Planning Application WA/57/20HH.

I have seen the plans for the roof extension and loft conversion with Dormer window to No.8 Prime Close, Walberton and I want to register my objection to the Dormer window extension on the front roof. This is totally out of character to the rest of the bungalows and extensions in Prime and Henty Close. All extended roofs fronting the road have Velux windows and these do not alter the appearance and character of the estate.

Project : Roof Extension  
Title : Elevations  
Drawing N.O : PL CC 0101 / 2020

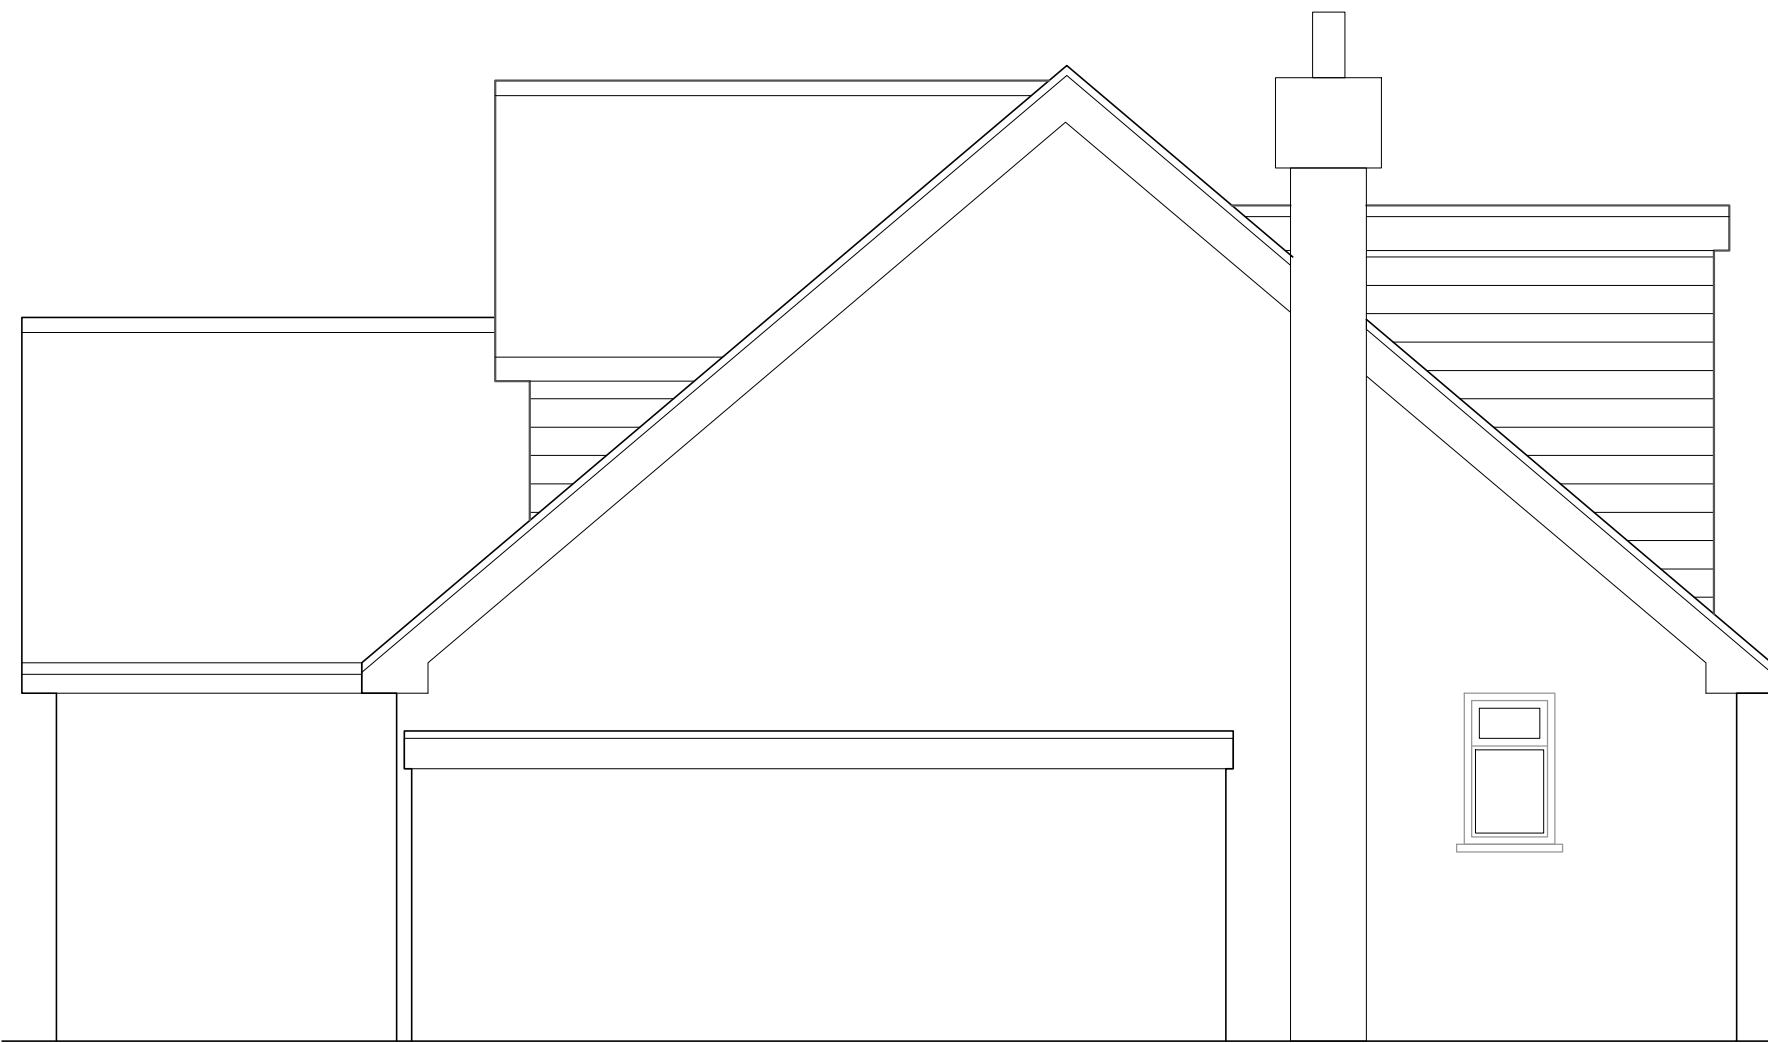
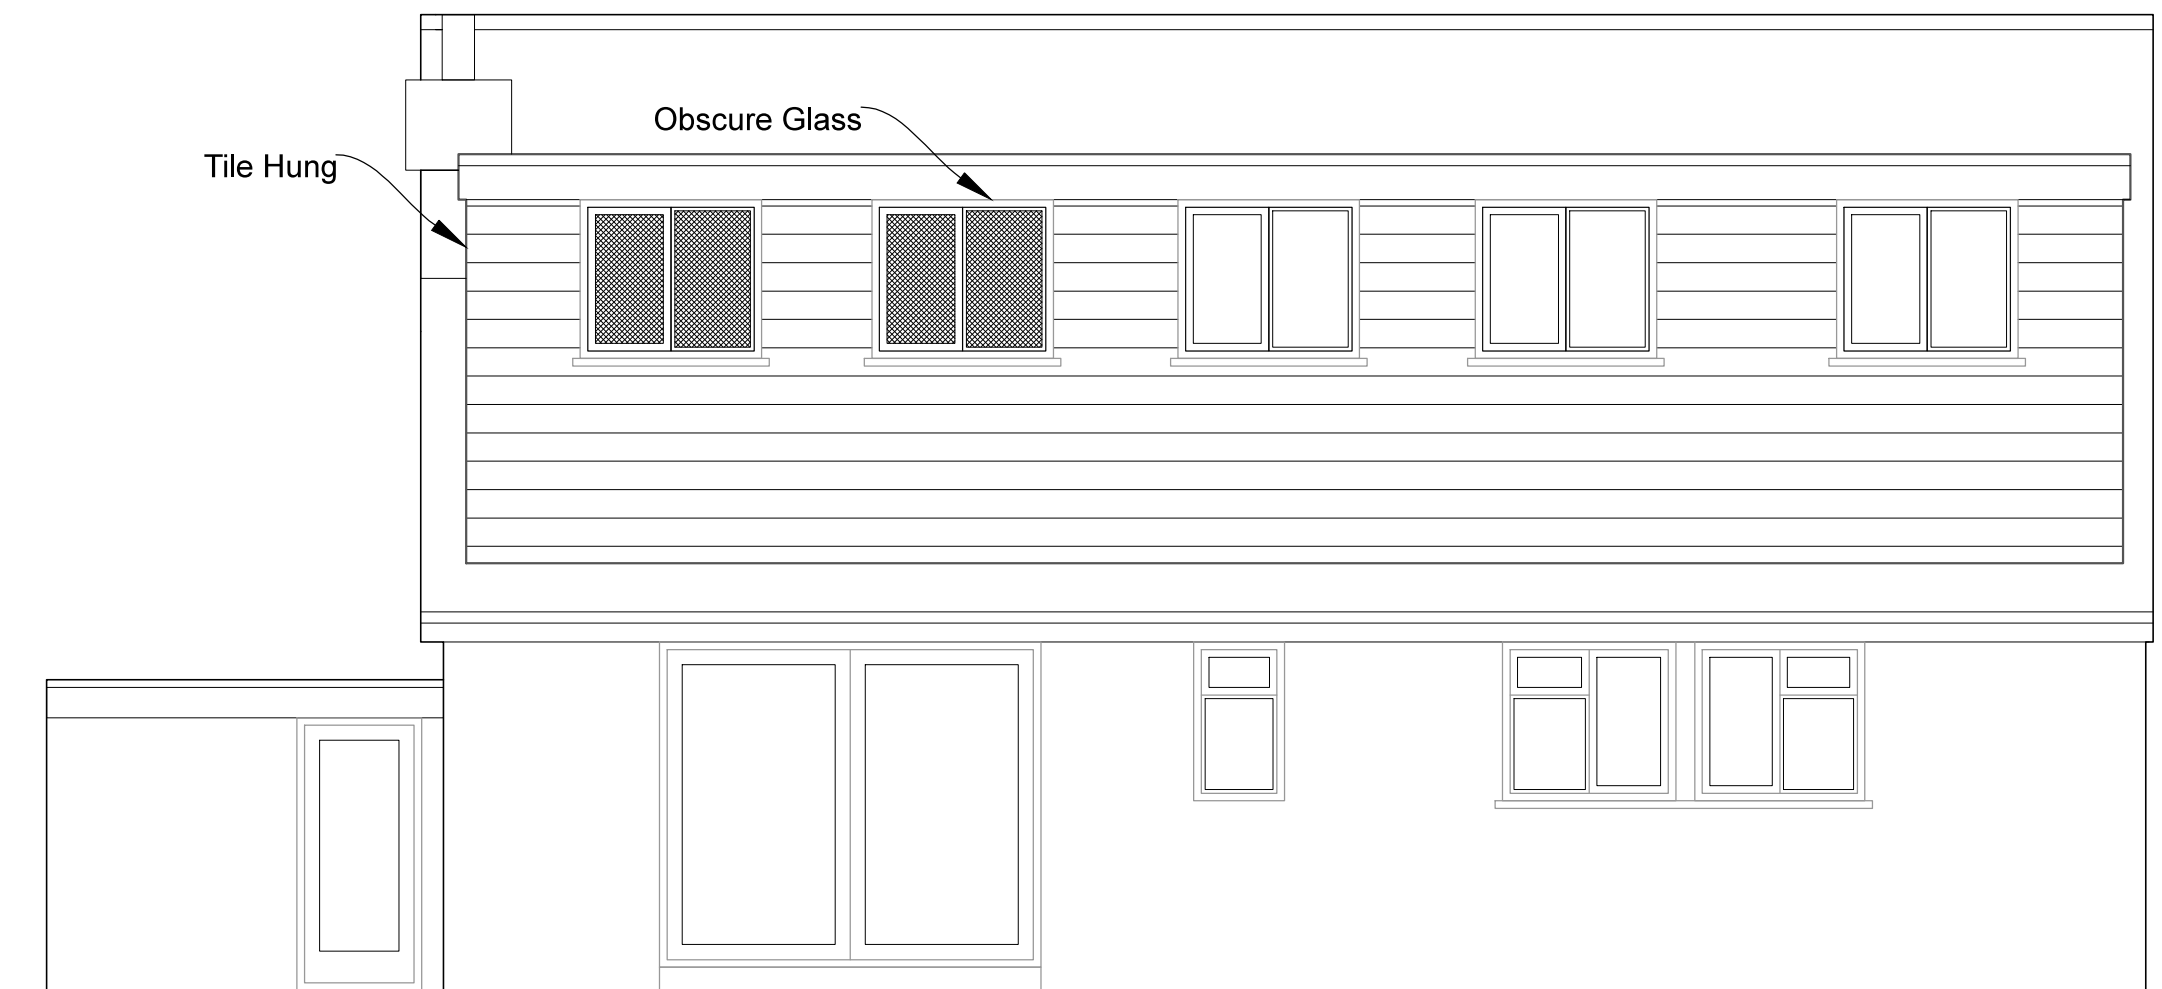
If you allow this Dormer window you will set a precedent for future applications.
